From: Simon Davis
Sent: 17 June 2021 15:02
To: [REDACTED]
Cc: [REDACTED] Christopher Best <christopher.best@arun.gov.uk>
Subject: RE: AL/49/21/DOC - Springfield, Hook Lane

Subject: AL/49/21/DOC - Springfield, Hook Lane

EAST ELEVATION
(1:50)

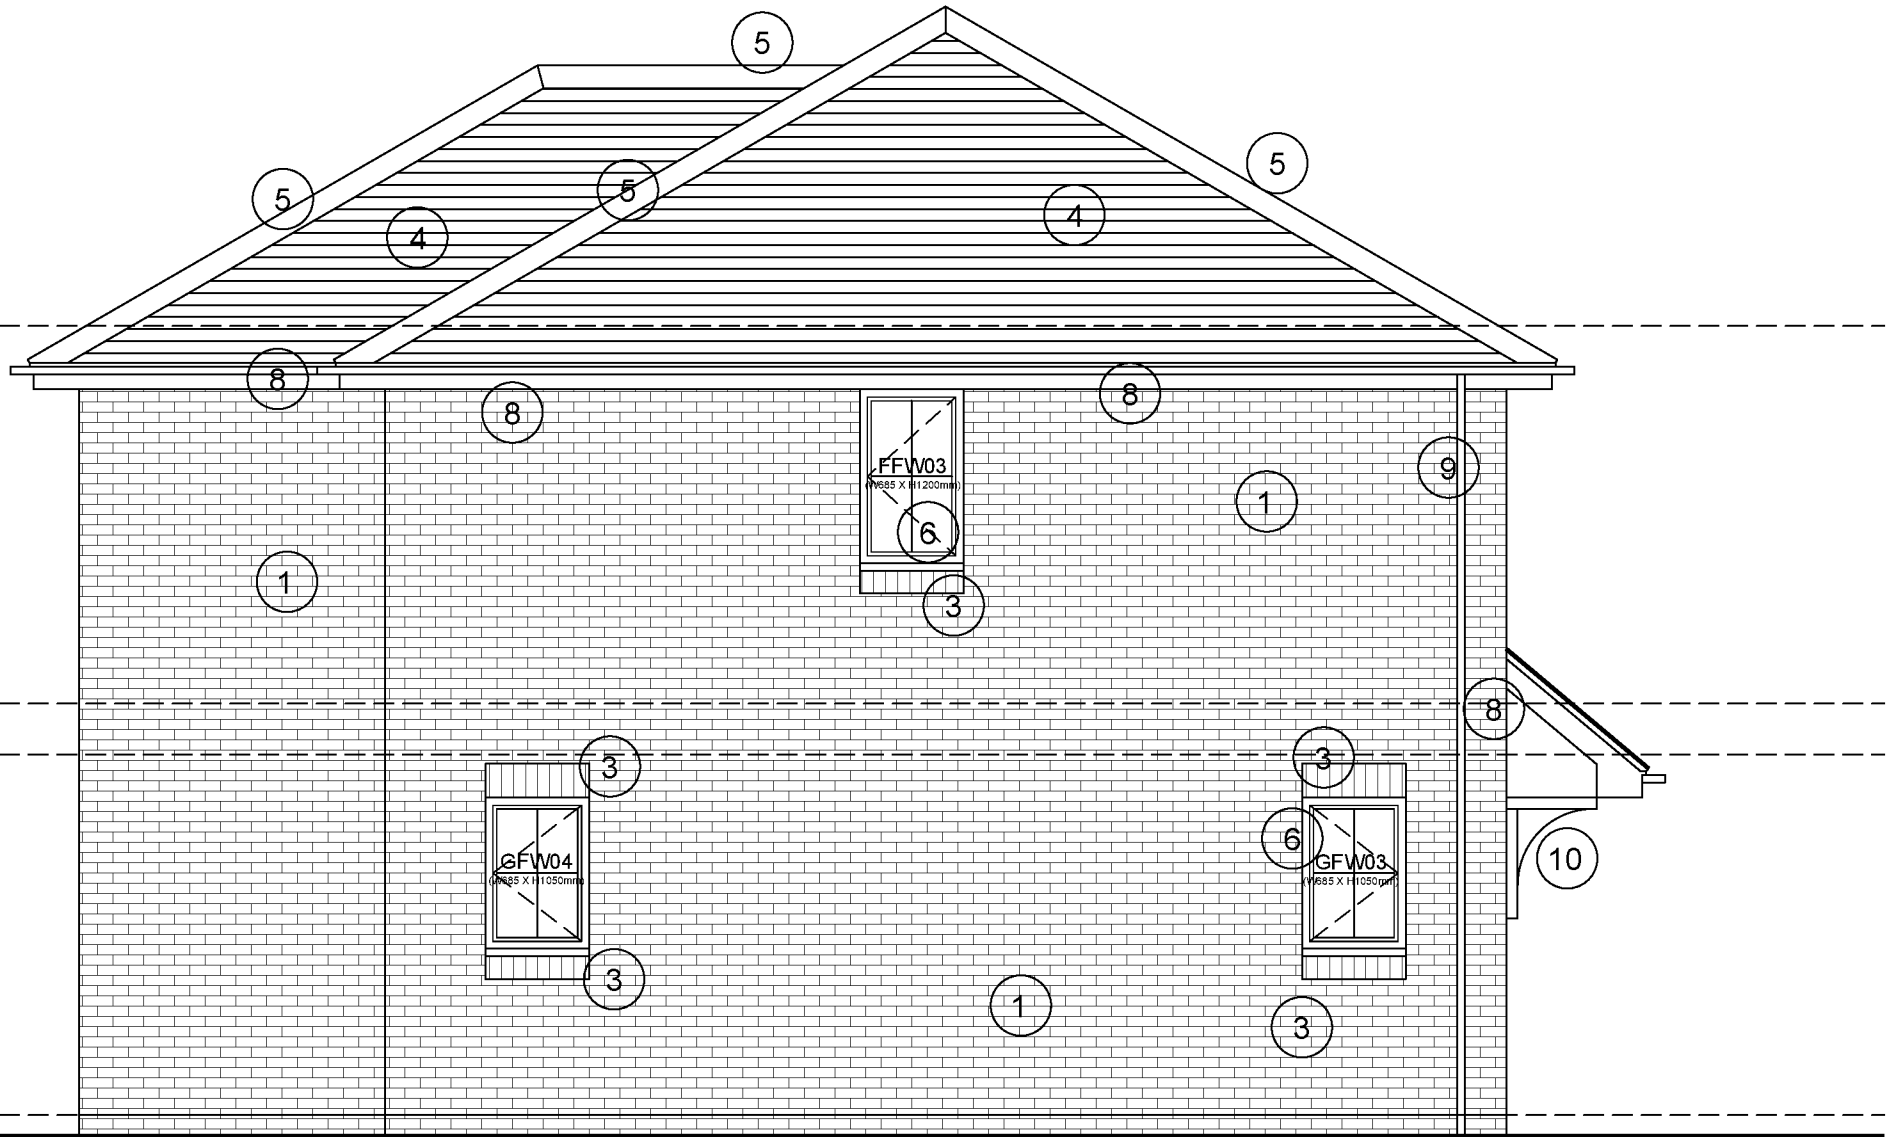
14	I have accepted the amended plans regarding the materials and I will be able to approve this.
15	As 13.
16	I did request that you respond within 10 days of my email dated 07/06 which you did meet. However, I have looked at the condition wording and see that it requires 24 new native trees but the plan provided shows only 12. I will therefore be refusing this condition on the basis of not meeting the condition requirements.
18	The use of Air Source Heat Pumps (as shown in the spec and the associated plan) is acceptable but there is no information to meet this part of the condition “.. <i>demonstrate that the development will achieve energy efficiency measures that reflect the current standards applicable at the time of submission</i> ...” It is not appropriate to just propose

IMPERIAL HOMES LIMITED			
CLIENT		HOOK LANE ALDINGBOURNE	
TITLE	TJK1973	SHEET	SHEET 1 OF 1
JOB NO.		DATE	MAY 2021
CHECKED BY	S.K.	DRAWN BY	T.J.K.
LEVEL DATUM	Stn GPS on survey issued		
		SCALE	1:200

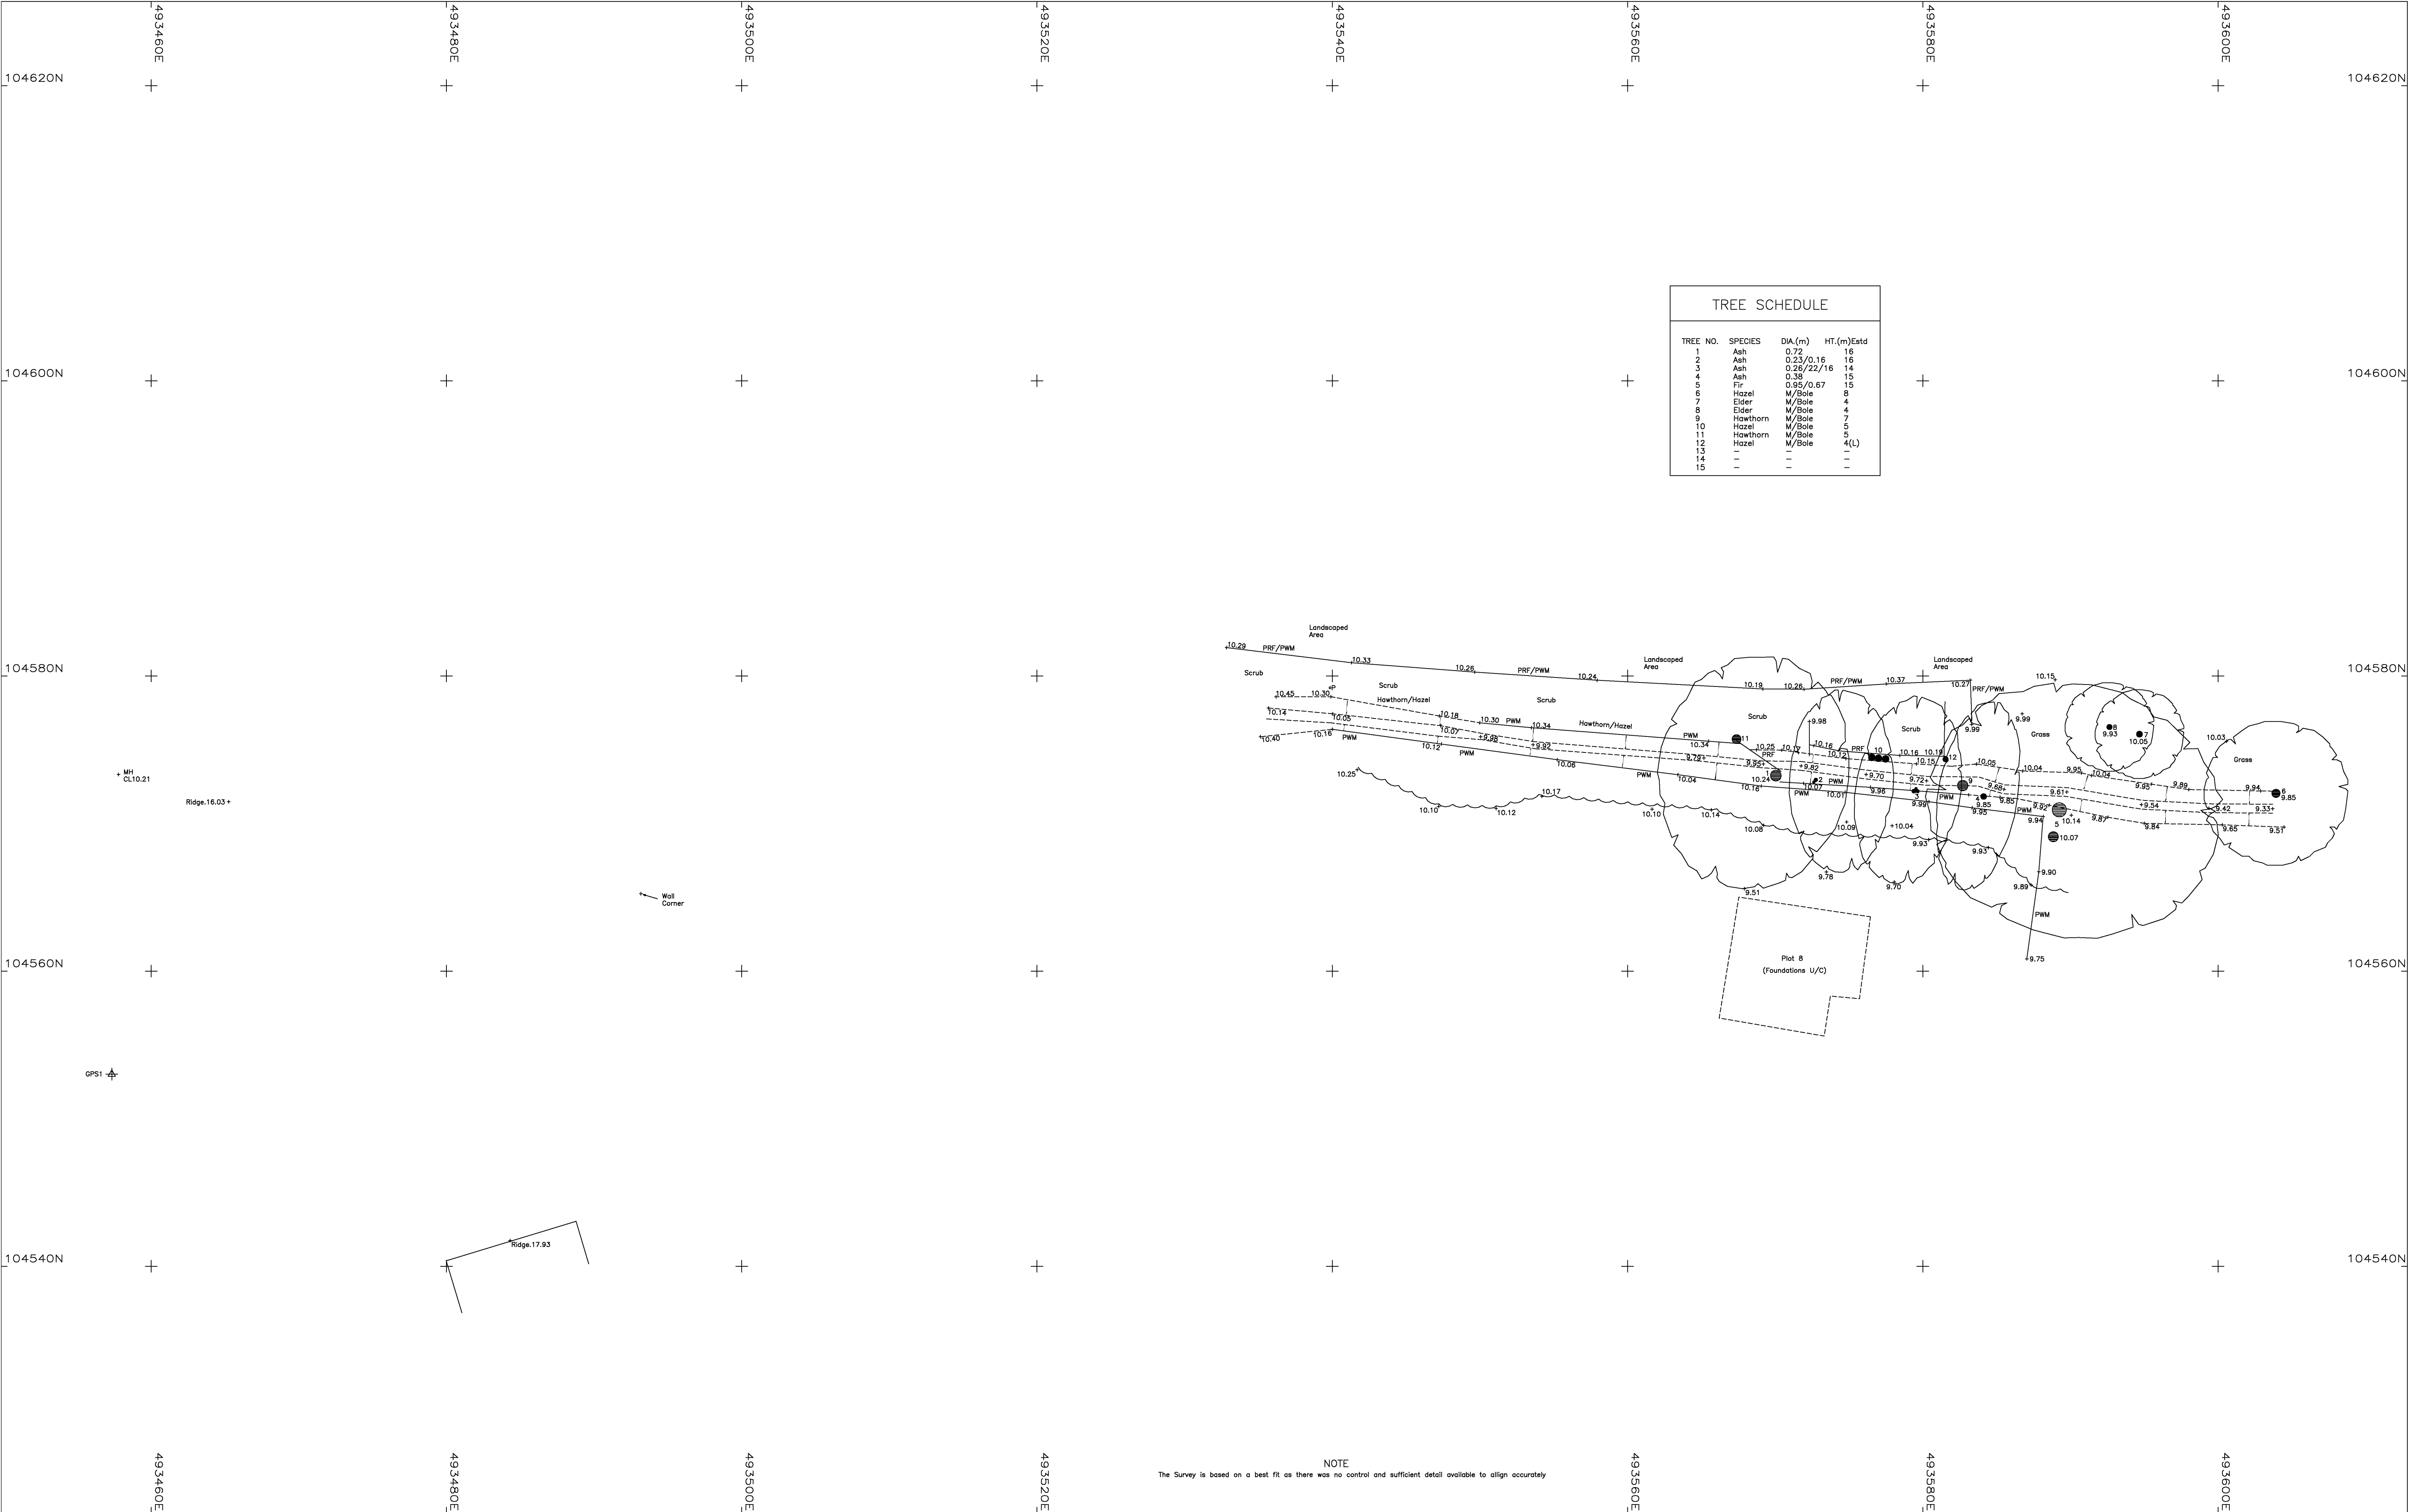
5) I have just emailed a report from our tree consultant direct to Mark and yourself which addresses all the issues. I really cannot understand why you cannot give some time for Mark to look at this and then the condition can be discharged. This is an important condition as it pre commencement. We have worked with Mark to address the issues and our tree consultant have done the report.

5	As you are aware, the Tree Officer has requested changes and then documentation to evidence these. I am aware that this is being actioned but there is currently only 7 days left until the application expiry and so no time to reconsult the Tree Officer. Therefore, this will be refused and you will need to resubmit.
6	There is insufficient time to reconsult our ecologist before the application expiry date of 22/06 however, I did request that you respond within 10 days of my email dated 07/06 which you did meet therefore I will reconsult the Ecologist regardless of the time limit.
7	No objection from our Archaeologist so I can approve this condition.
8	WSCC have raised no objection and Env Health have made no comments therefore I can approve the CMP condition.
13	There is insufficient time to reconsult our Drainage Engineer before the application expiry date of 22/06 however, I did request that you respond within 10 days of my email dated 07/06 which you did meet therefore I will reconsult the Drainage Engineer regardless of the time limit.

- 5) I have asked Mark to respond by the 22nd. If he is not able to do this then I will refuse as per my previous advice.
- 16) The 24 tree requirement was imposed at the request of our ecologist who requested that any trees to be lost be replanted on a 2:1 ratio to ensure biodiversity net gain (which itself is a policy requirement). However, if this is unachievable then you would need to justify why.
- 21) Ok its just that other developers in discharging such conditions provide a letter/email from BT open reach confirming that the site is capable of achieving broadband speeds of 24MB. I have been looking at Y/58/21/DOC this morning where this has been provided.
- 25) If you can get your own ecologist to state that the light fitting is bat friendly or similar wording then we could accept it.
